J. P. Tupper Associates

Re: 49 Warren Way, Barnham
Ref: BN/48/19/HH

I refer to your letter of the 12th July 2019 and I am able to reply as hereunder:

Dwg No.: 7631/05

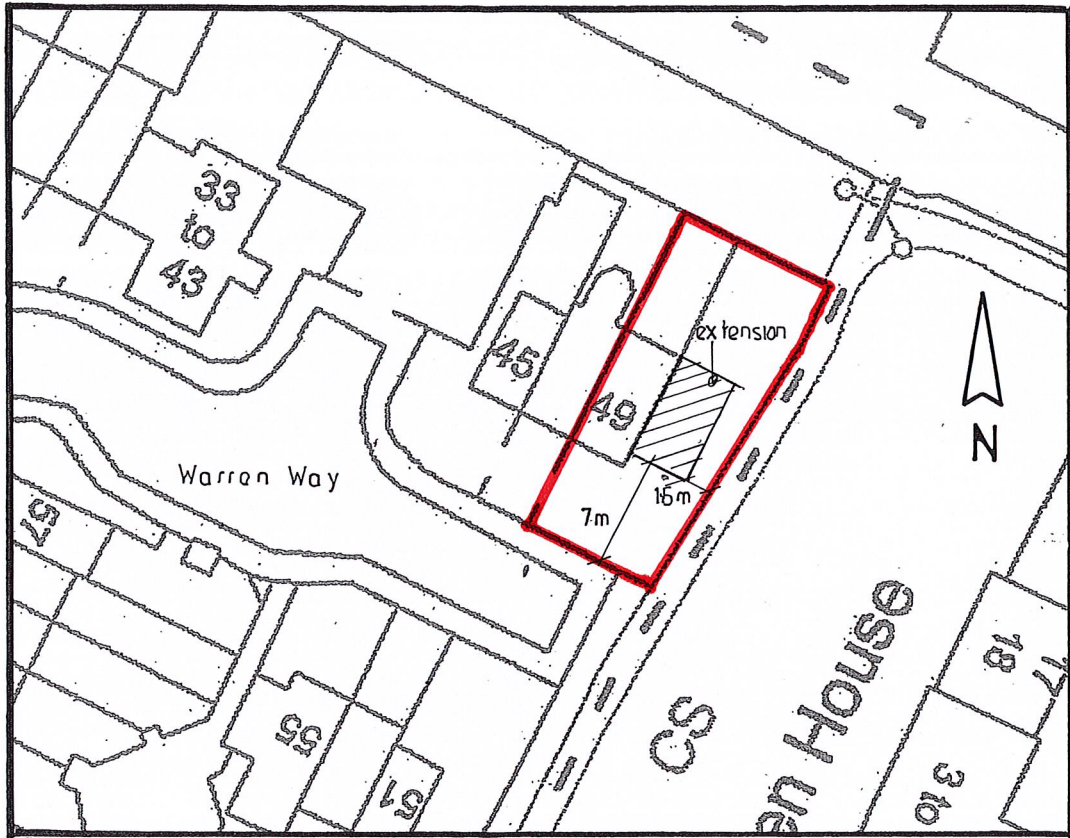
The actual dimension to the front boundary of the property, as depicted on the Block Plan is 9.25M.

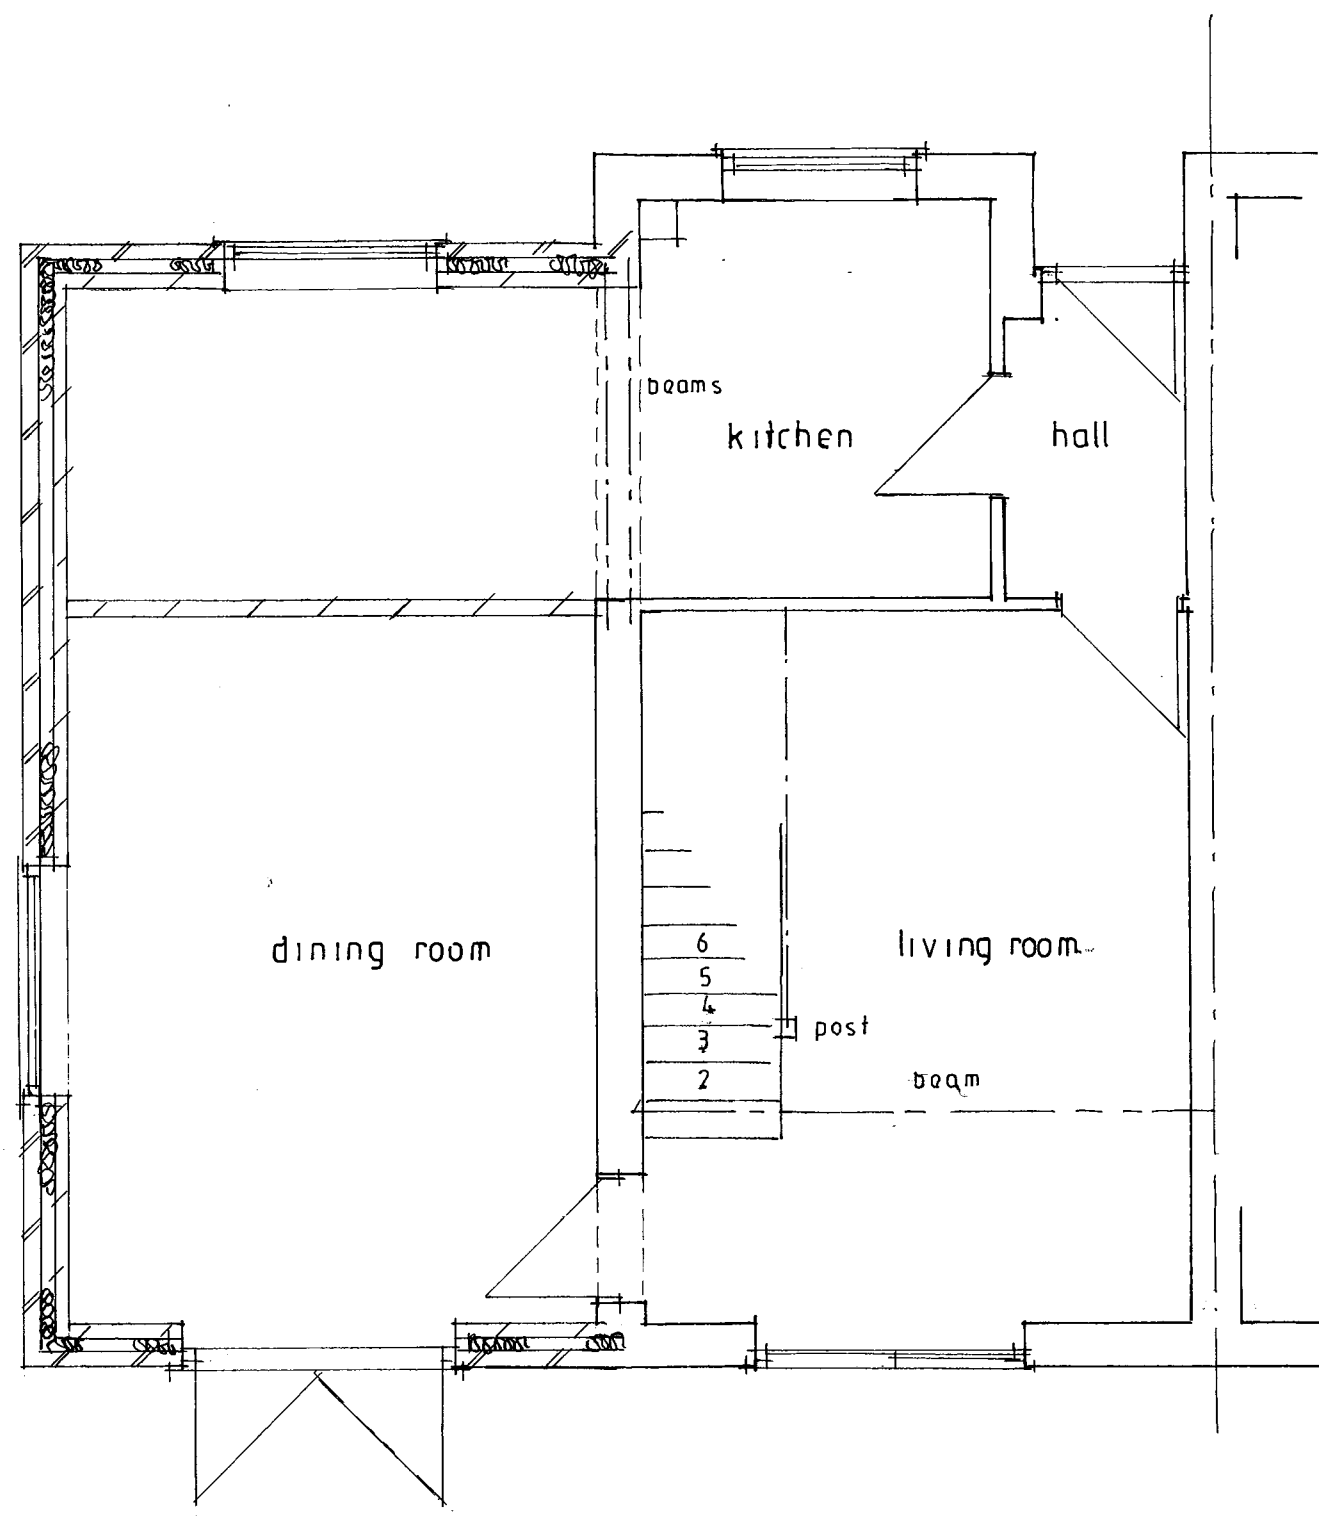
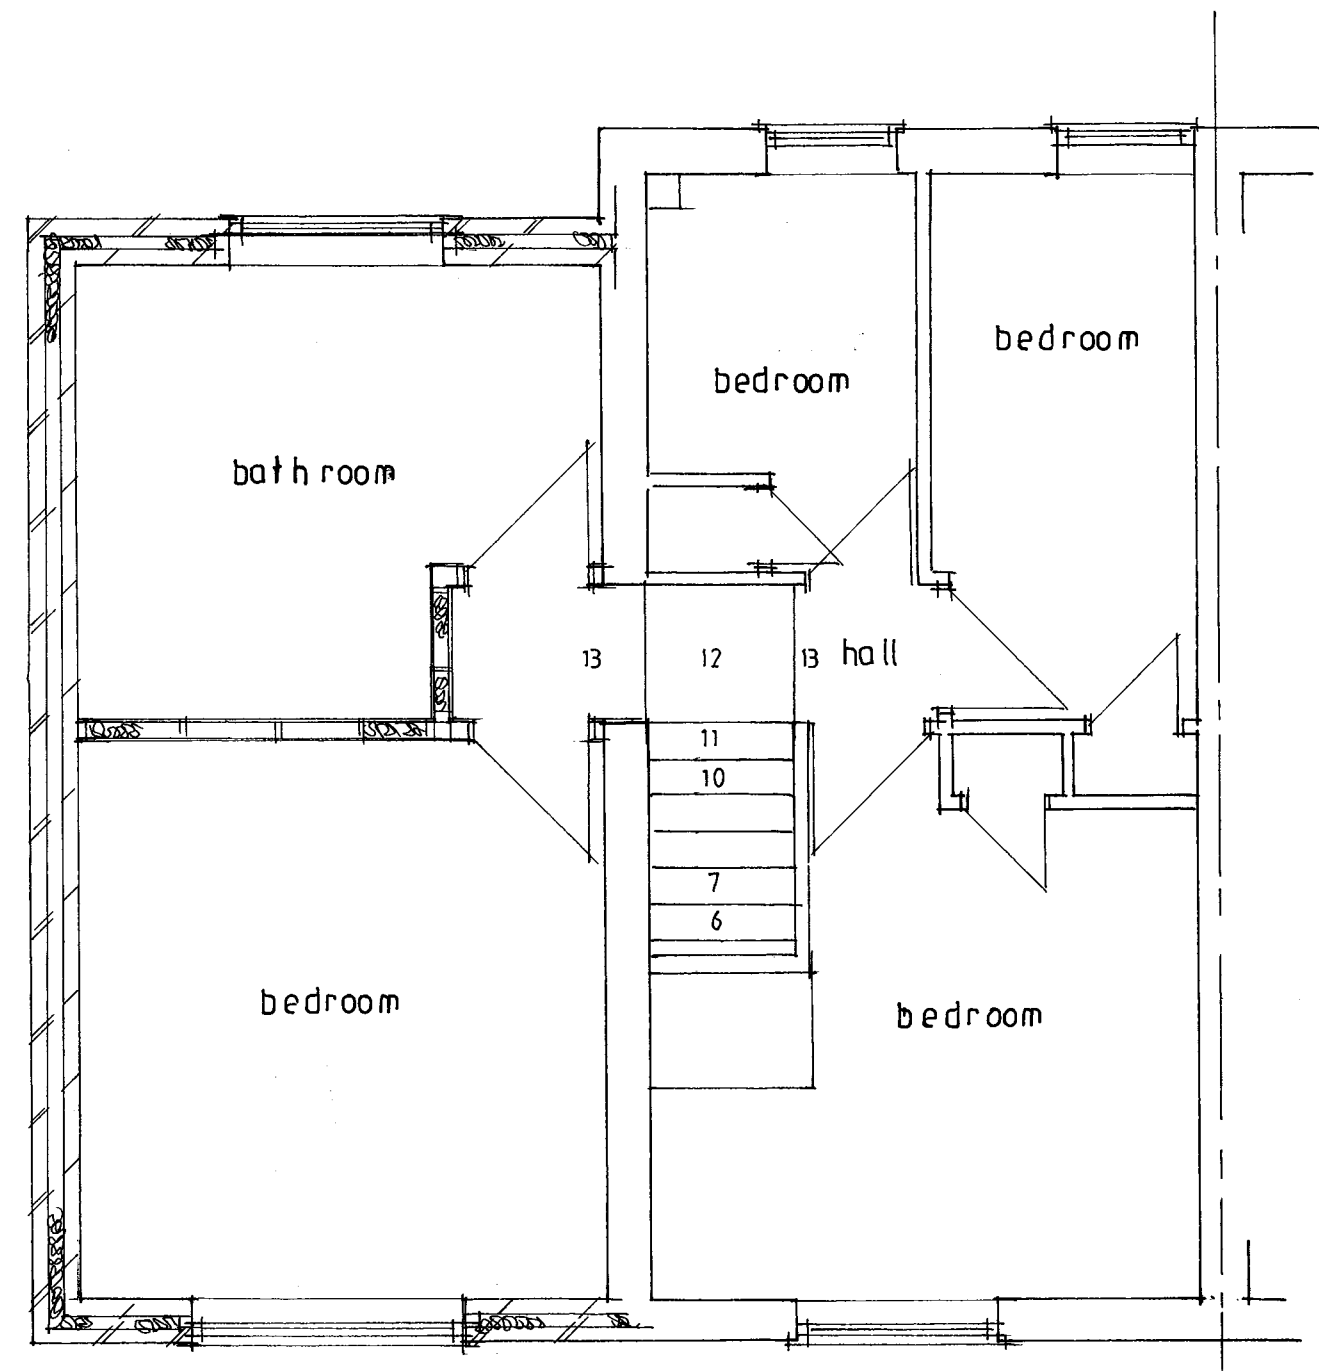
Reference to the Plan deposited 7631/02A clearly indicates that the proposed Ground Floor is a Dining Room and it is proposed that the extension shown from the Kitchen will not contain any new equipment, which would require to discharge water from the property. In general terms, the Kitchen will remain as shown and previously approved.

On the First Floor the original Bathroom will be re-sited only.
